Planning Application Ref: AW/256/19/T

Location: 22 St Richards Drive, Bognor Regis, PO21 3BJ

Description of works: Thin epicormic growth & reduce overall crown by 2.5m & reduce 3no. main branches overhanging neighbouring garages by 0.5-1m, back to boundary line to 1no. field maple tree

12 ST RICHARDS DRIVE TWIN STEMS OF ACER CAMPESTRE

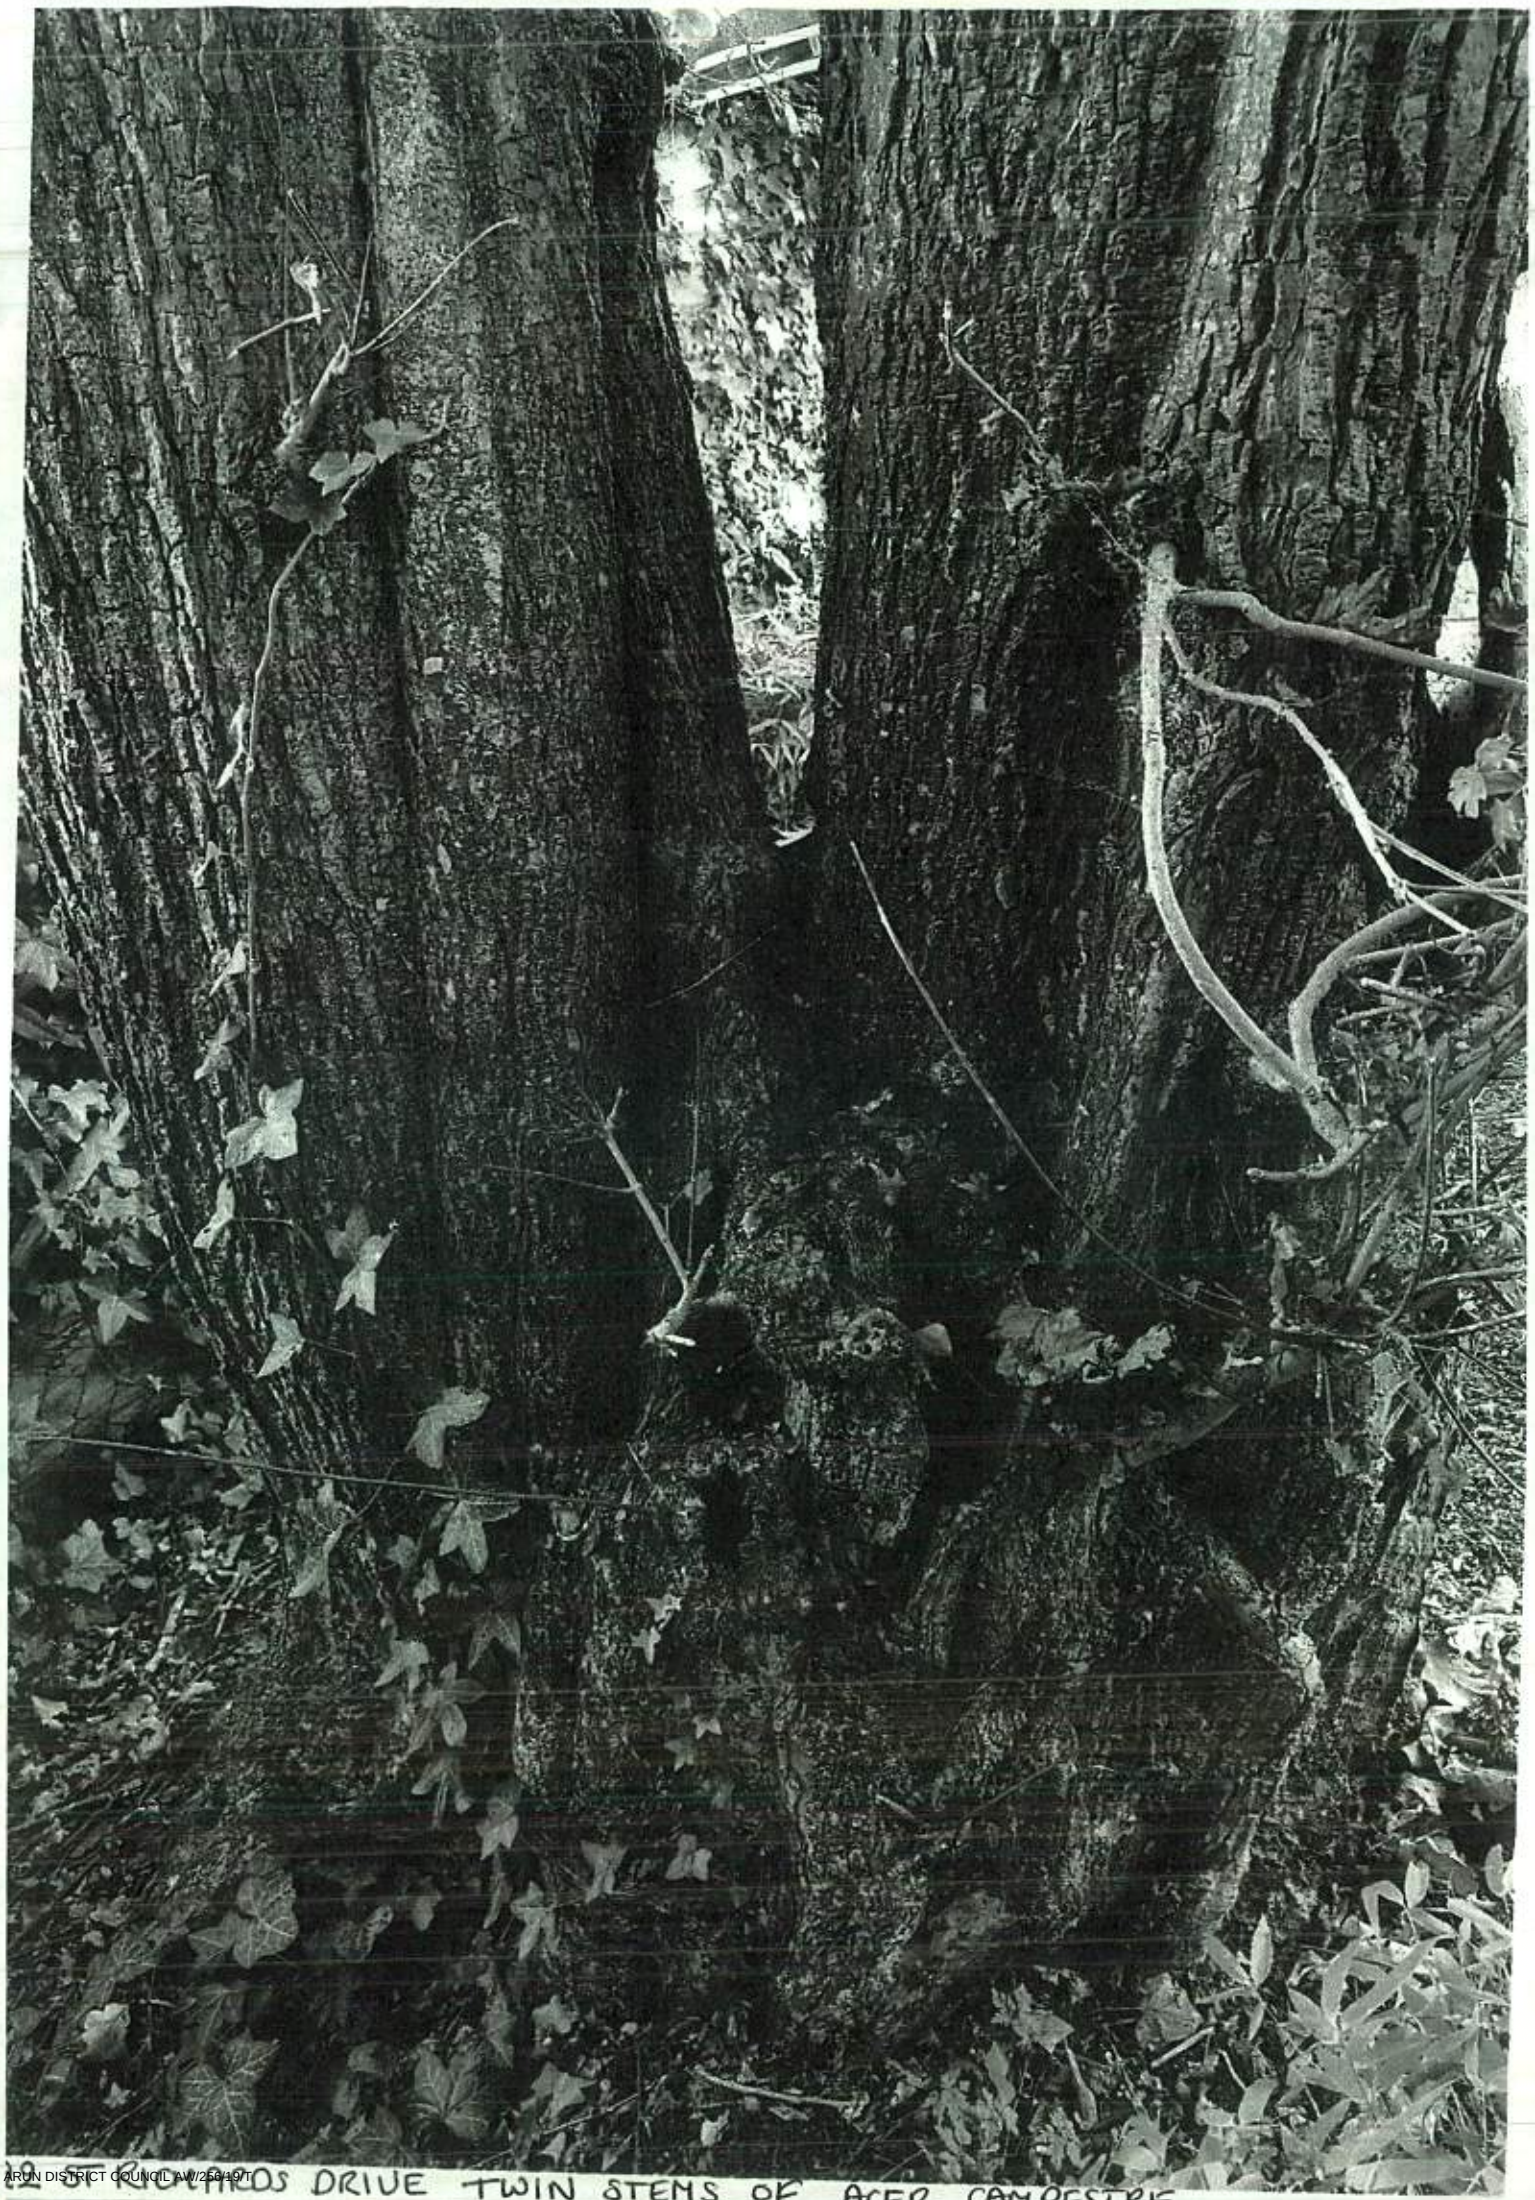
- Despite the co-dominant stem and large near basal wound this tree appears to be in fair physiological condition and free from obvious structural defect at this time. It has a heavily modified crown, being subject to a reduction (pollard) in the past.
- It grows at the rear of the property and can be seen from neighbouring dwellings but has only limited visibility from publicly accessible land.
- Repeat operations such as now being asked for by the applicant will be necessary throughout the remaining life-span of this tree, to achieve a reasonable degree of structural integrity appropriate for its location.

- Part a) Where whole branches are to be removed and final cuts made close to the trunk or branch union they are to be made as shown in Figure 2 of BS3998:2010
- Part b) Where branches are to be shortened back the final cuts are to be made at the correct angle shown in BS3998:2010 and adjacent to a live bud or lateral.
- Part c) The removal of crown material which has developed since the last operation must be done sympathetically and with respect to established 'knuckles' so as not to extend beyond the point of origin.
- Part d) The long-term vitality of these trees is best respected when significant pruning work such as proposed, is undertaken during either the summer (June to August) or mid-winter (late-December to early-February) periods. The work must only be undertaken during these periods.
